A14 Cambridge to Huntingdon Improvement Scheme

**These notes are a summary of the CTC Cambridge oral submission
as presented to the Issue Specific Hearing held on September 16 2015**

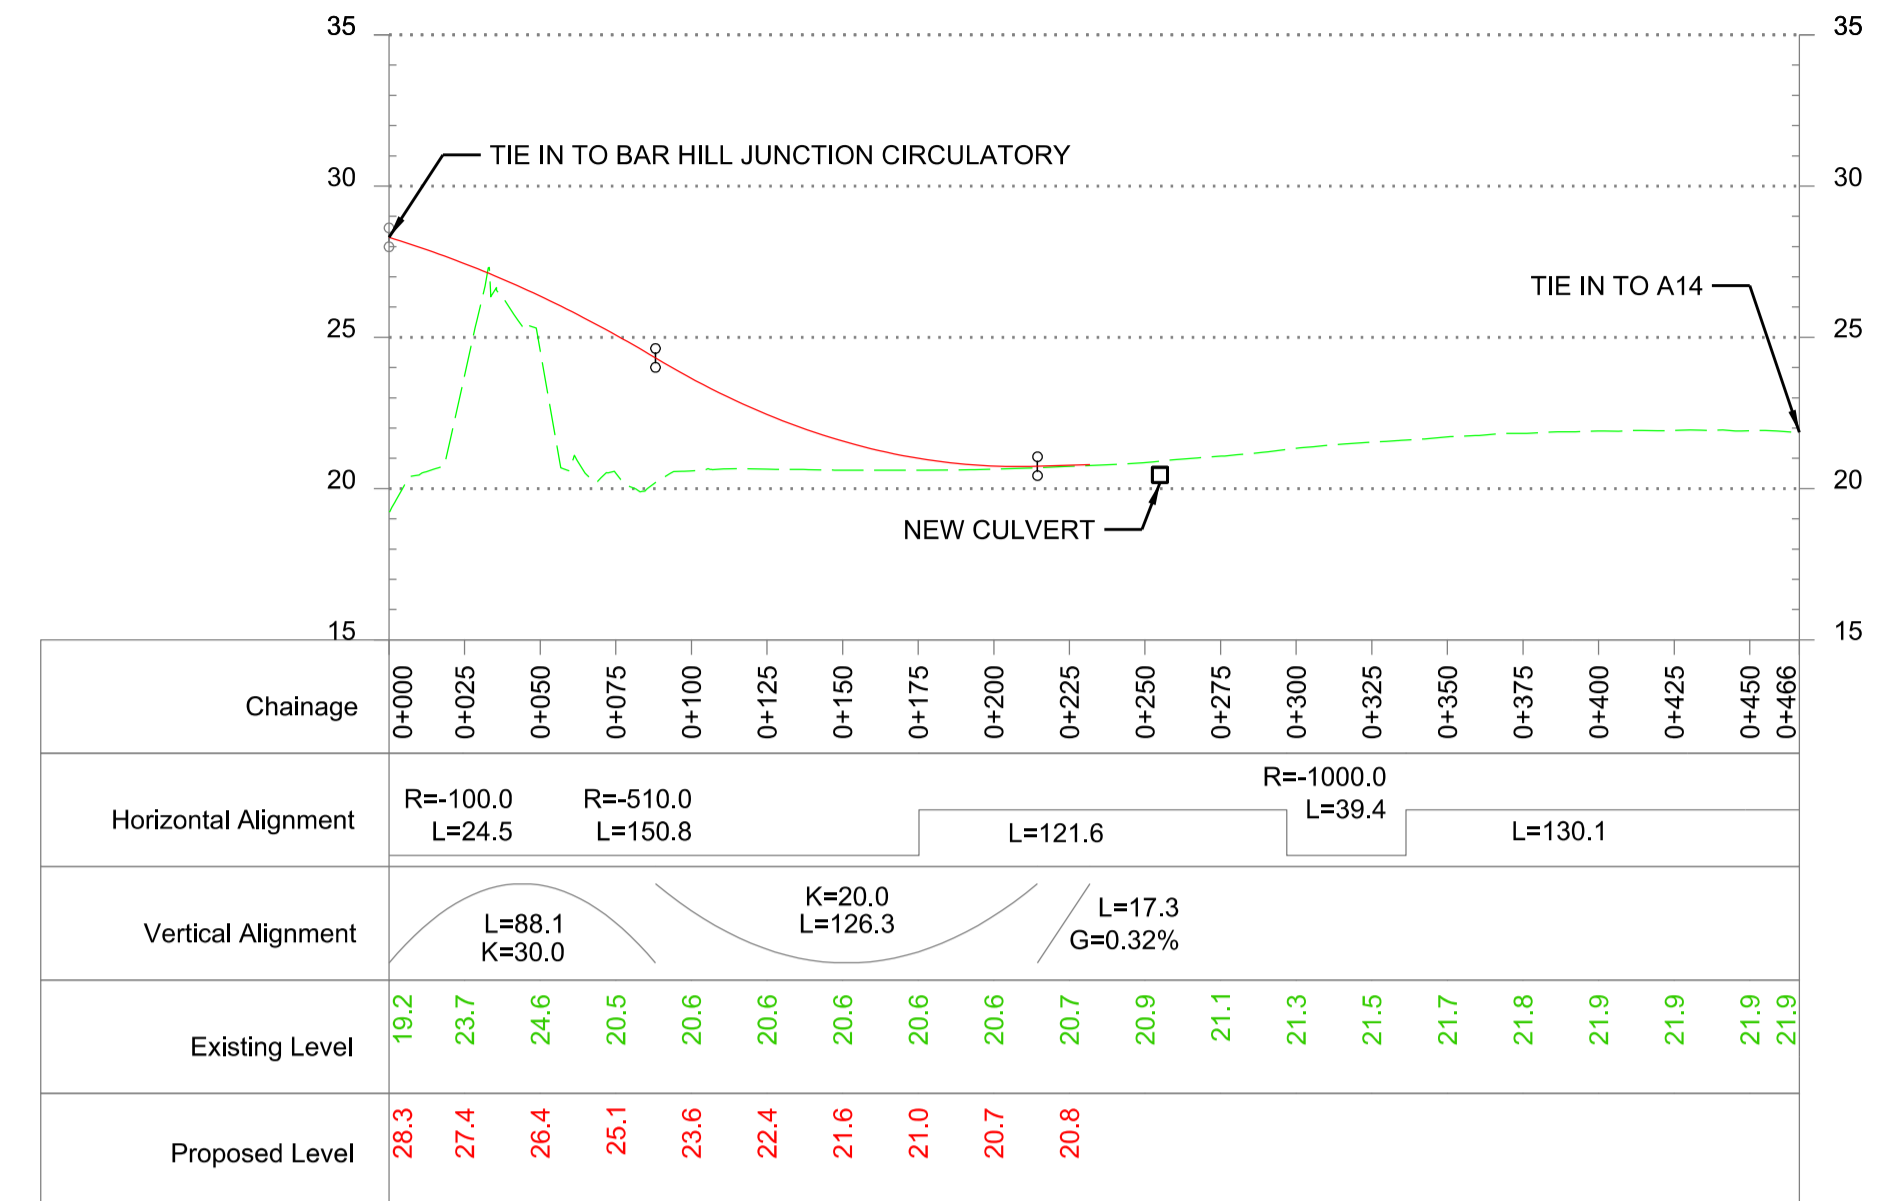
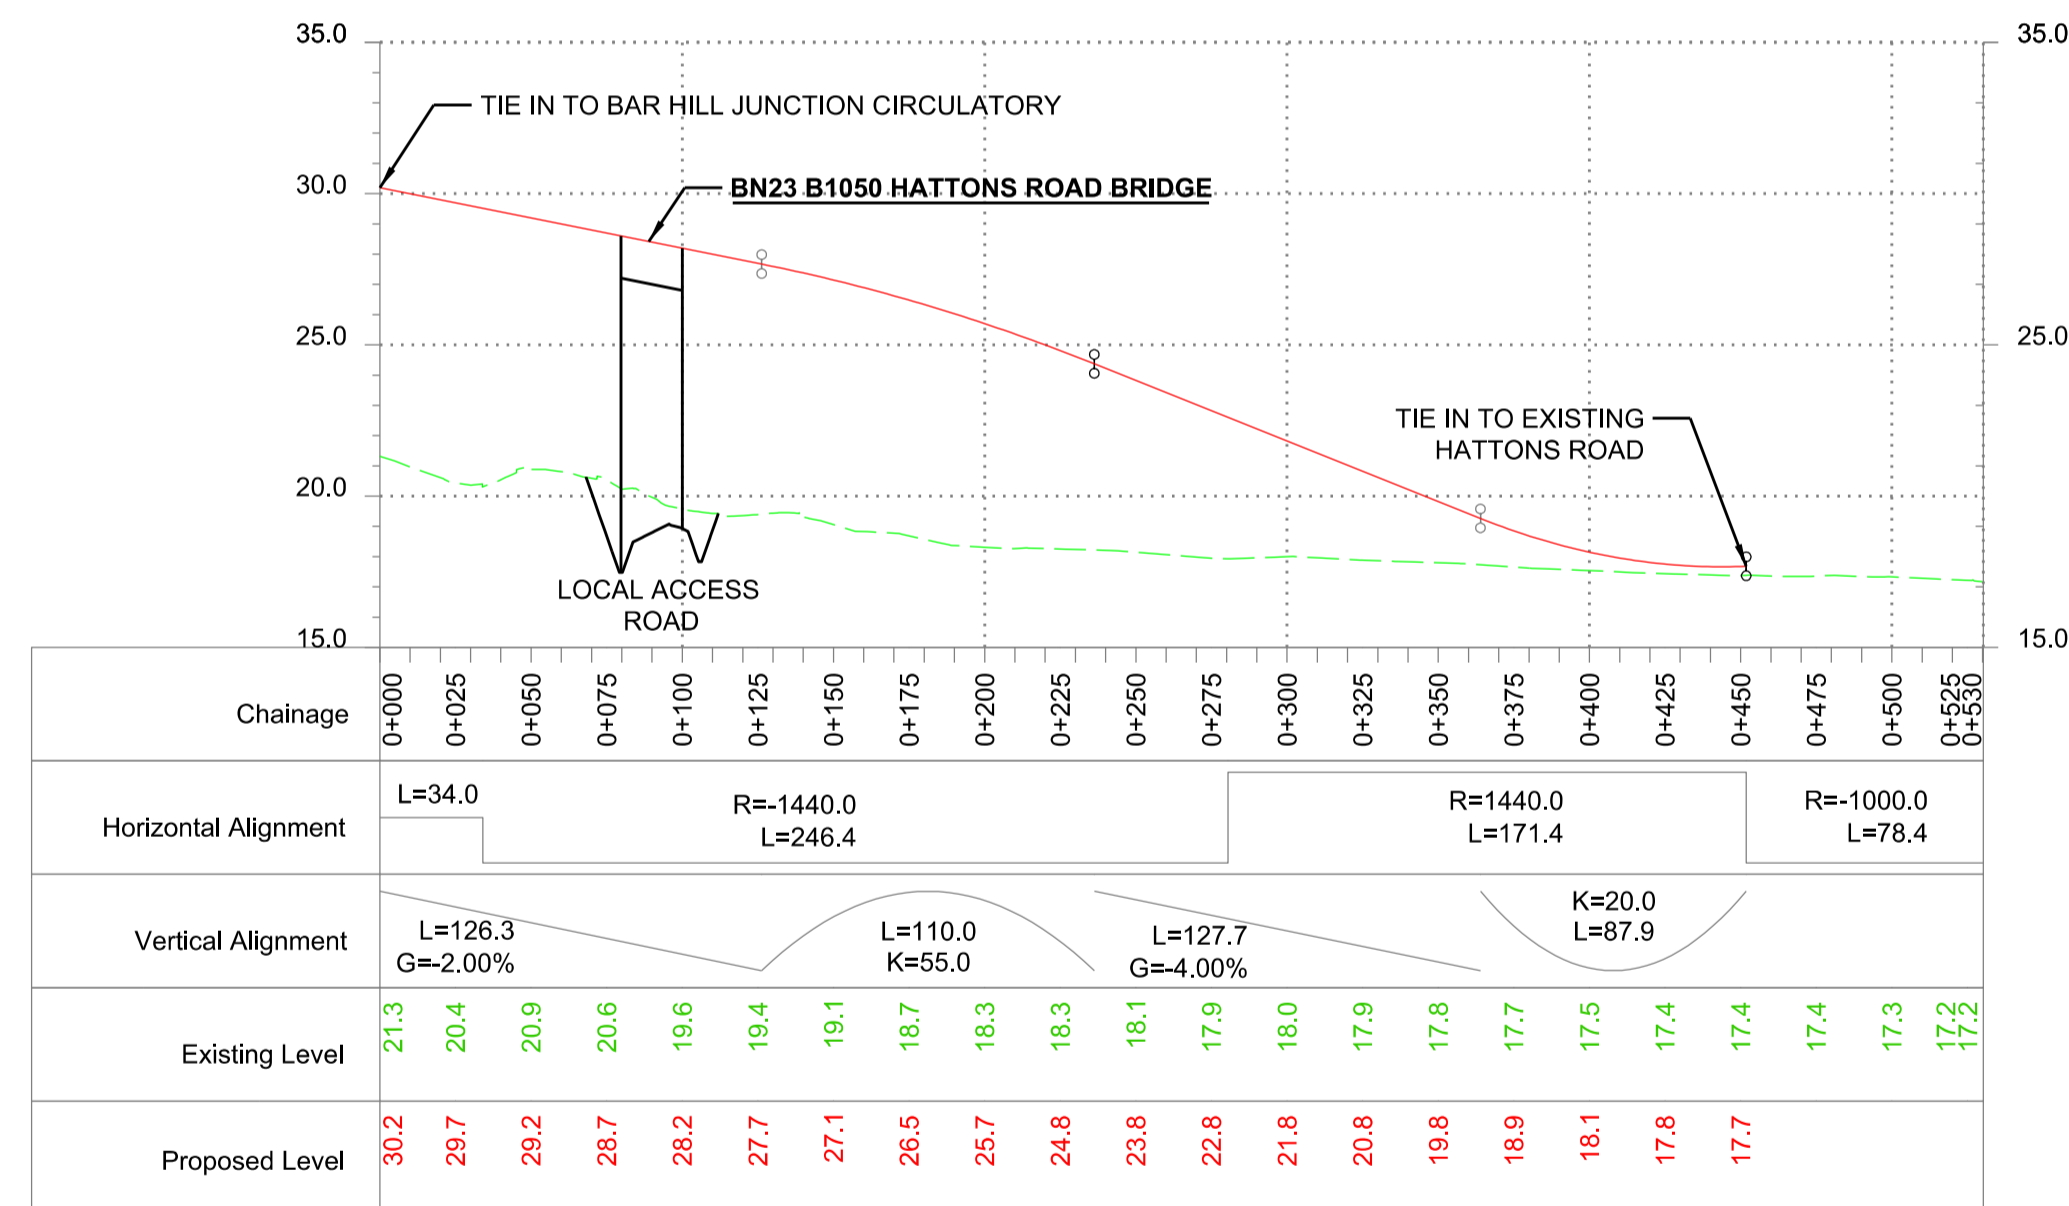
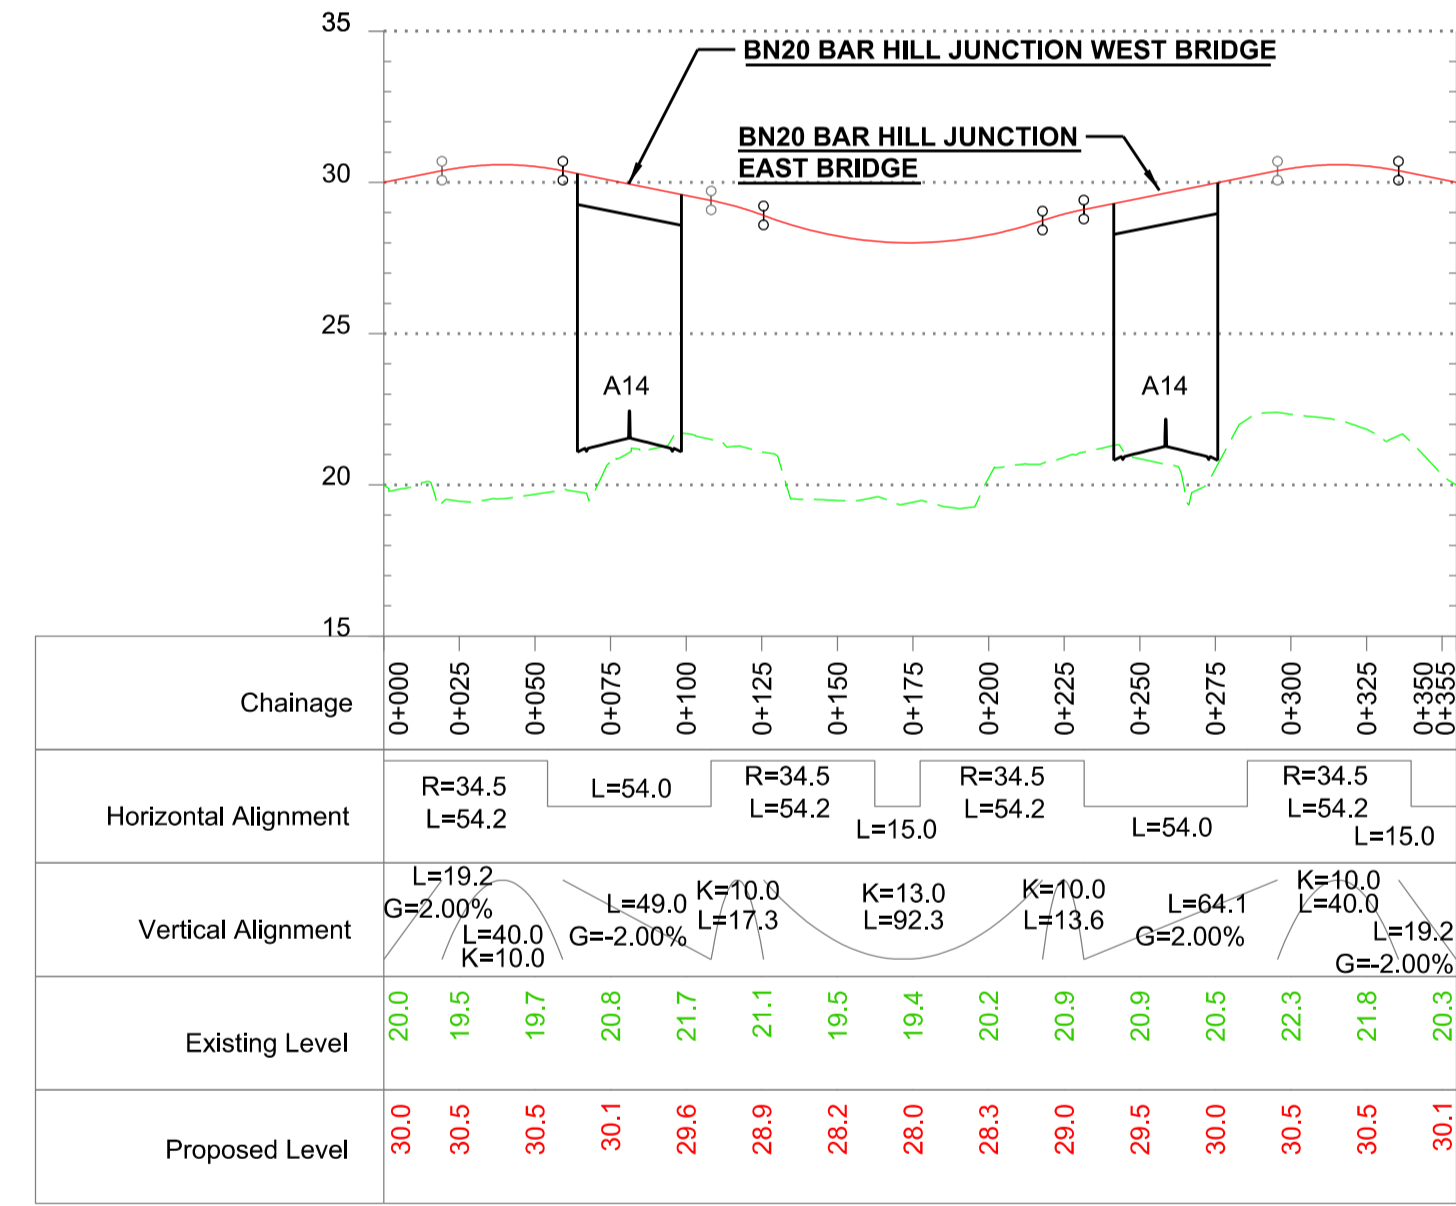
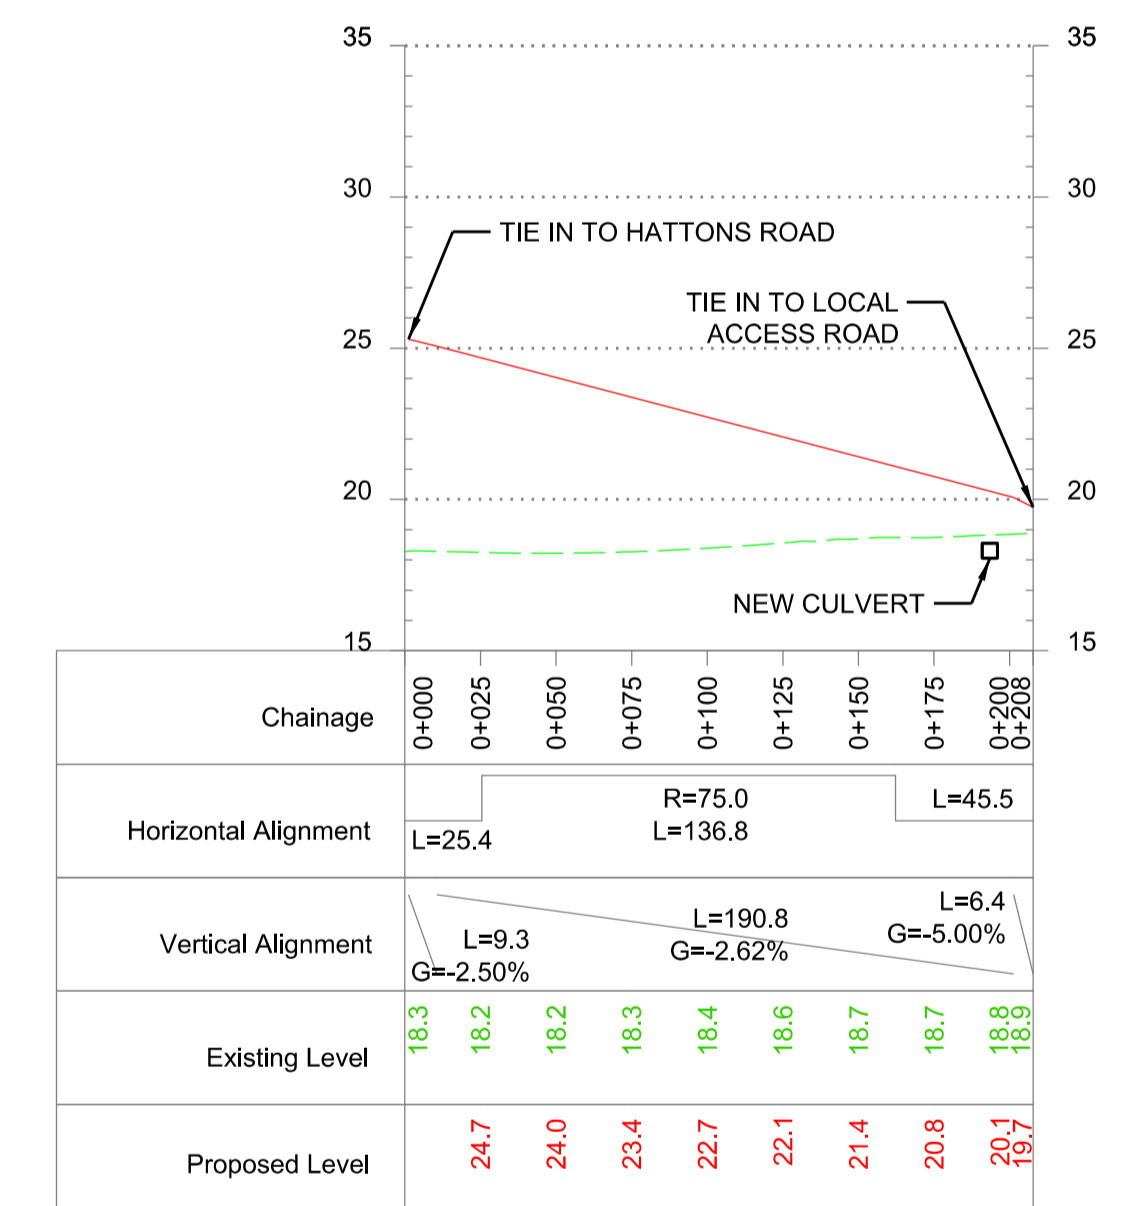
The most important condition is to ensure the width of the planned routes. I understand that a width of 4m is proposed for the first section from Girton to Bar Hill, reducing to 3m beyond the Bar Hill junction. This is a good standard of provision and I simply ask for the conditions to ensure that these widths are maintained in the final design.

But I also want to ask for a second important condition: to add more separation between these NMU paths and the edge of the carriageway to allow space for some sound and light screening. I understand these NMU paths are currently located at the edge of the carriageway. This close spacing makes for unpleasant cycling and walking. By simply moving the paths a little further away – say 2m away from the edge– the impact of the motor traffic is reduced. In particular it allows space for a small hedge or other barrier to shield NMUs from the impact of headlights at night. Let me explain why this matters. Approaching headlights (even when dipped) cause severe loss of night vision making cycling difficult. On a quiet road this can be managed, but on a busy road with many vehicle movements, the impact is severe and the path is much less pleasant to use.

I understand the verge of these roads will include an approx. 8m wide swale for drainage, and it seems relatively simply to adjust the arrangement to achieve this 2m separation. This is a modest proposal that would make a lot of difference for very little added cost.
